Subject: Nelson Rezone (RZ-08-00011) & Nelson Short Plat (SP-08-00046)
Parcel # 20-17-31052-0001 and 20-17-31052-0006
SR 970, MP 7.16 Rt ±

TO: Allison Kimball, Community Development Services
FROM: Christina Wollman, Planner II *CW*
DATE: December 5, 2008
SUBJECT: Nelson Short Plat SP-08-00046 and RZ-08-00011

Thank you for the opportunity to comment on the Nelson Short Plat, SP-08-00046. The parent parcel was last subdivided in 1993. According to the Memorandum of Agreement with Washington State Department of Ecology and Kittitas County dated April 7, 2008, regarding management of exempt ground water wells in Kittitas County; new uses for residential purposes on parcels created before March 28, 2002 are not subject to the agreement.

NELSEN SHORT PLAT
 PART OF SECTION 31, T. 20 N., R. 17 E., W.M.
 KITTITAS COUNTY, WASHINGTON

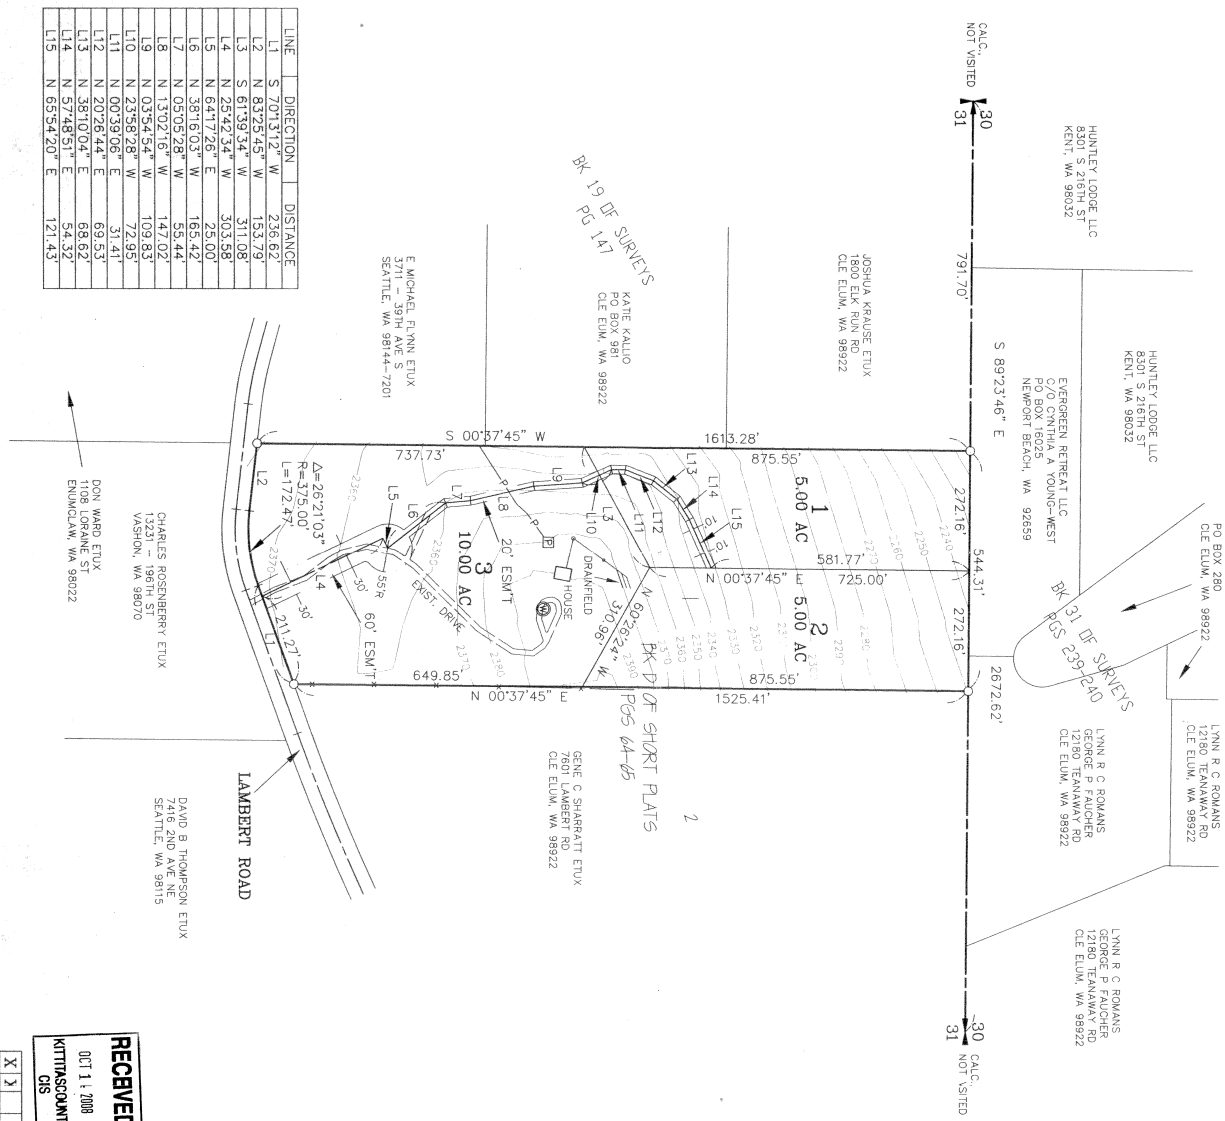
4. Private Road Improvements: Access from Lambert Road to the cul-de-sac shall be constructed as a Low-Density Private Road. See Kittitas County Road Standards, 9/6/05 edition.

5. Cul-de-Sac: A cul-de-sac turn-around having an outside right-of-way or easement diameter of at least 110 feet shall be constructed at the closed end of all dead-end roads serving 3 or more lots. The driving surface shall be at least 96 feet in diameter. Cul-de-sacs must also conform to the requirements specified by the 2006 International Fire Code. Contact the Fire Marshal regarding any additional cul-de-sac requirements.

The potable water plat note is incorrect (plat note #8). Please replace the plat note with the following:

Please also include the following plat note:

"The approval of this division of land includes no guarantee that there is a legal right to withdraw groundwater within the land division. The approval of this division of land provides no guarantee that use of water under the ground water exemption (RCW 90.44.050) for this plat or any portion thereof will not be subject to curtailment by the Department of Ecology or a court of law."

"Metering will be required on all residential well connections and metering results shall be recorded in a manner consistent with Kittitas County and Washington State Department of Ecology requirements."
